## **Development Facilitation Team (DFT) – Review Comments**

**Project No: PR-2024-011198   Date: 02/12/2025   Agenda Item: #6   Zone Atlas Page: L-14**

**Request: Minor Subdivision plat to consolidate Lots 5 and 6, Block 2 of Gregorio & Rafael Apodaca Add. Into one new lot, and dedicate 3.6 feet or more of additional right-of-way to Jesus St SE**

### **Application For: MINOR PLT-2025-00002 – MINOR PLAT**

Plat for
Lot 5-A, Block 2
Gregorio & Rafael Apodaca Addition
Being Comprised of
Lots 5 and 6, Block 2
Gregorio & Rafael Apodaca Addition
City of Albuquerque
Bernalillo County, New Mexico
December 2024

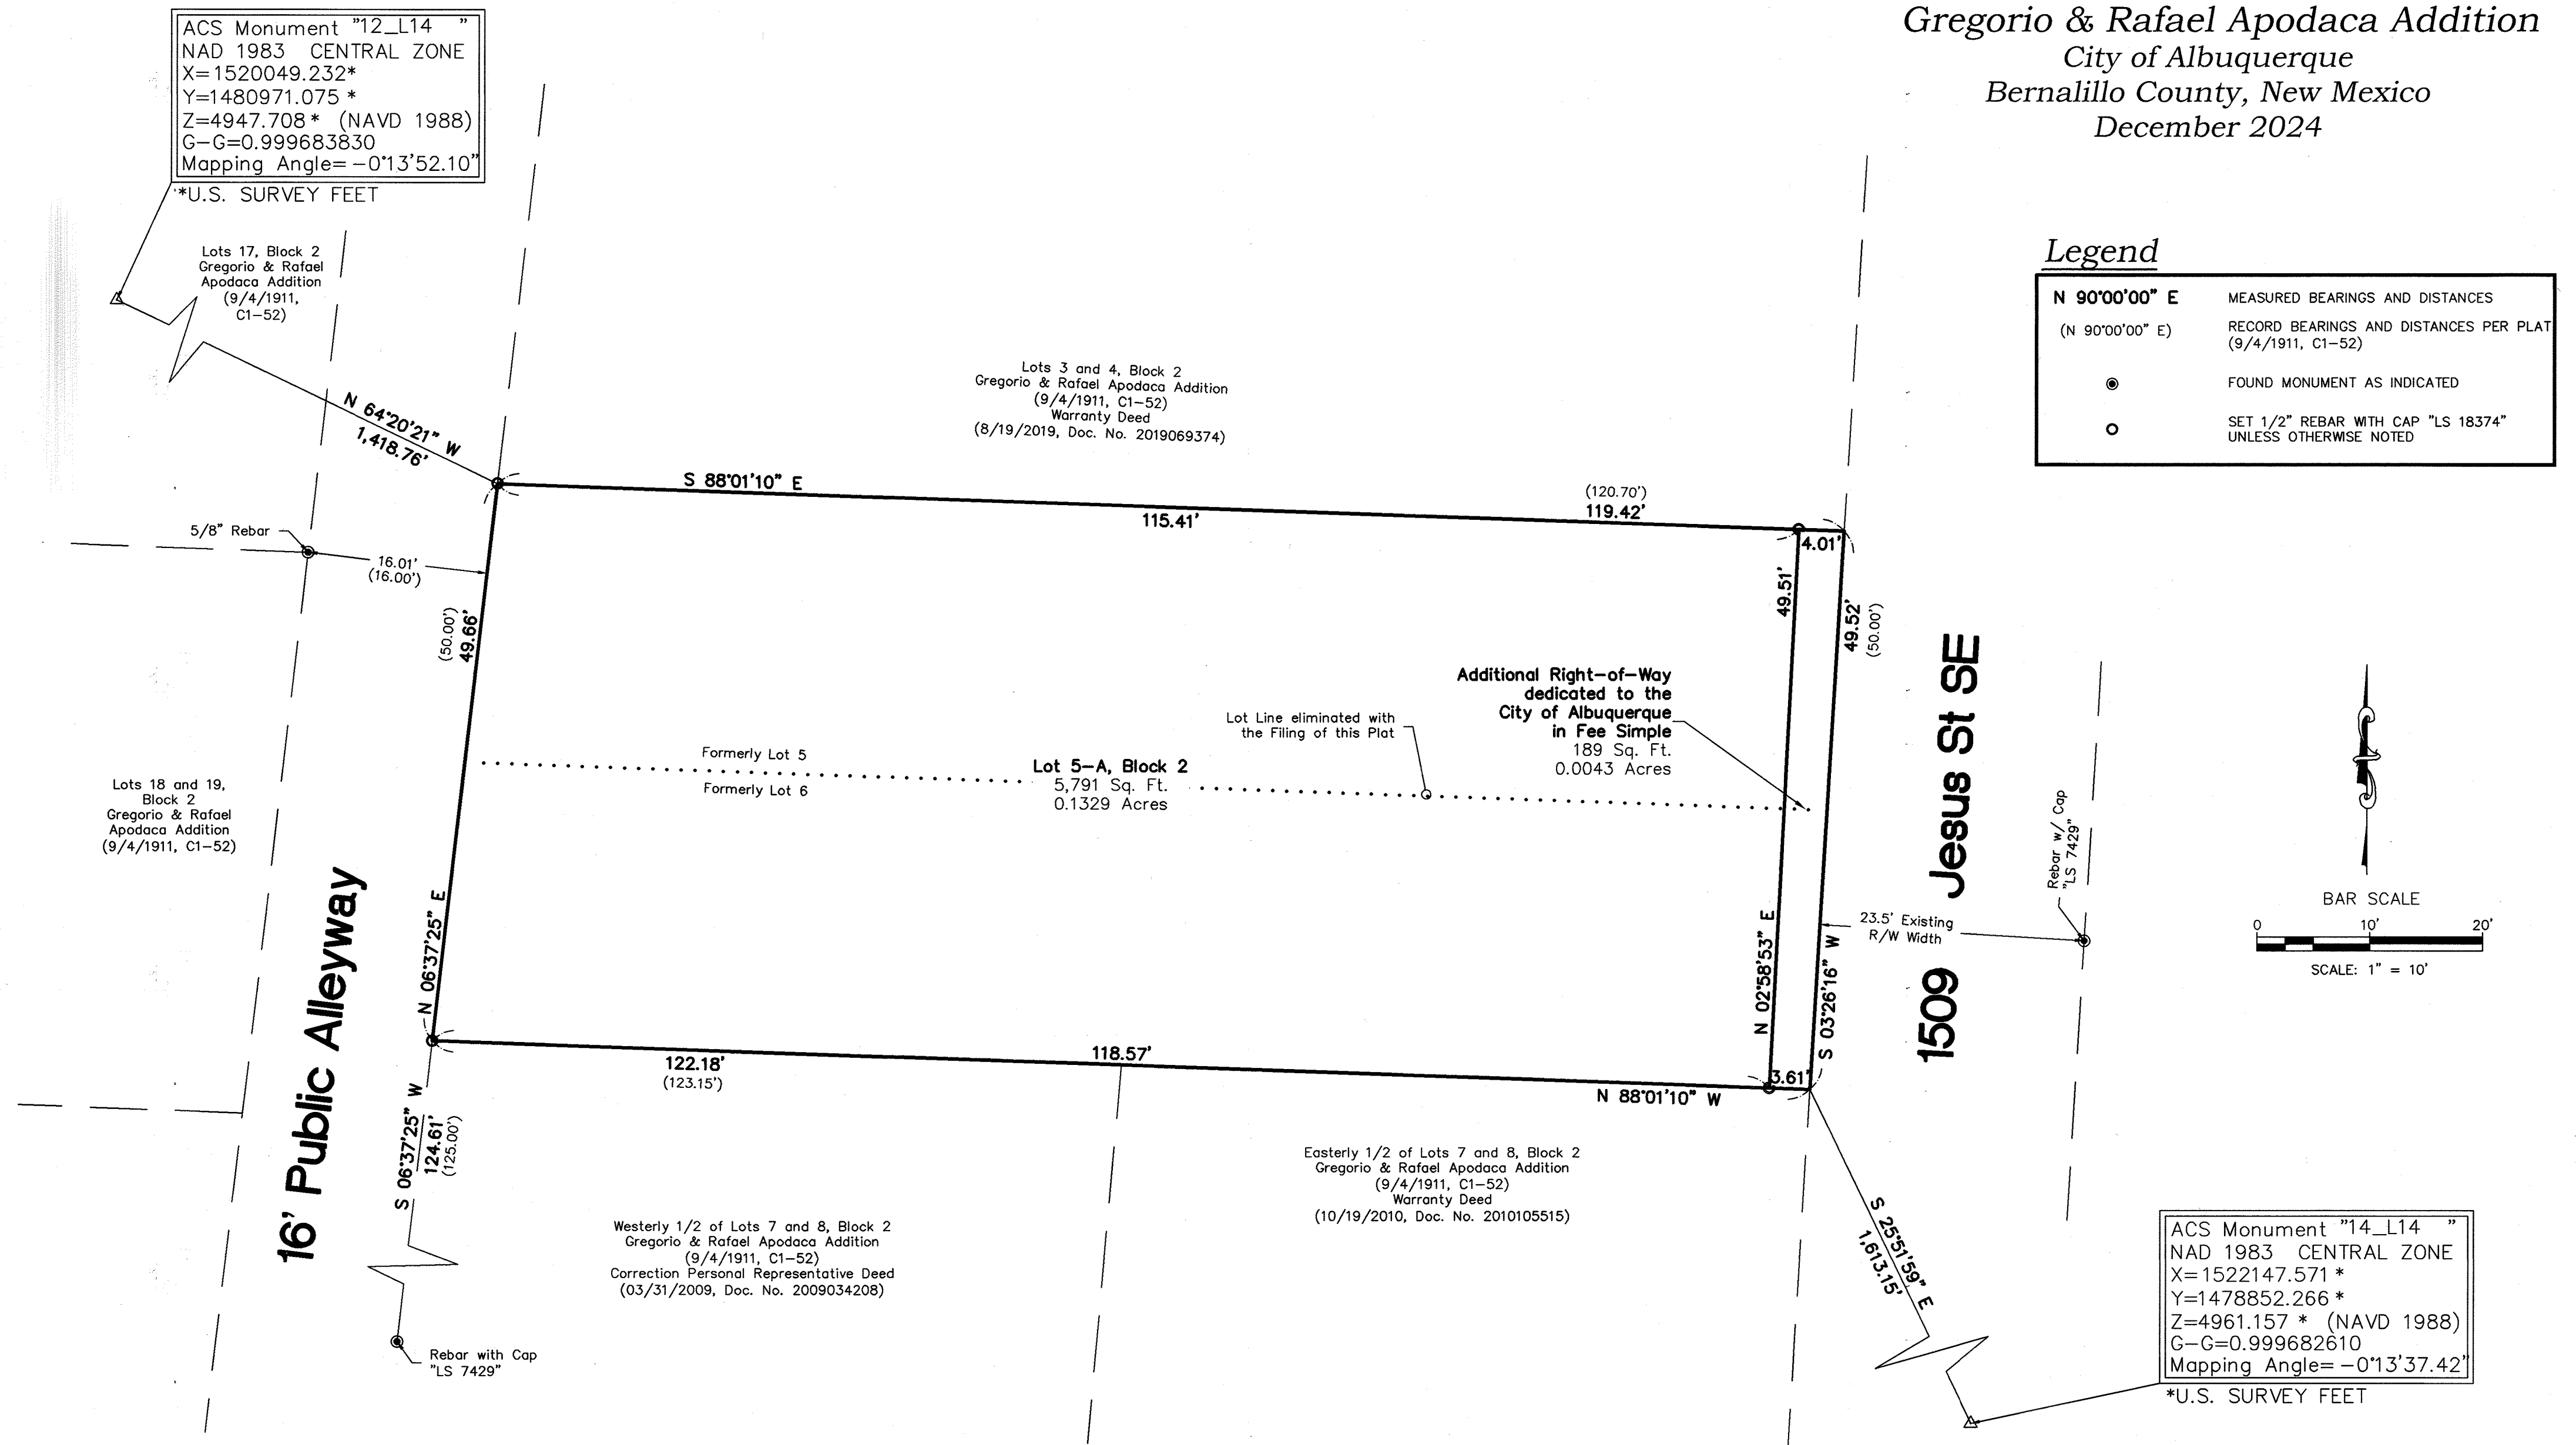
- The application number and date of DHO approval must be added to the Plat.
- Proof of approval of the DXF file from AGIS must be provided.
- Planning defers to Transportation regarding the DHO Determination request; Transportation notes in their memo that they have no objection to the request.
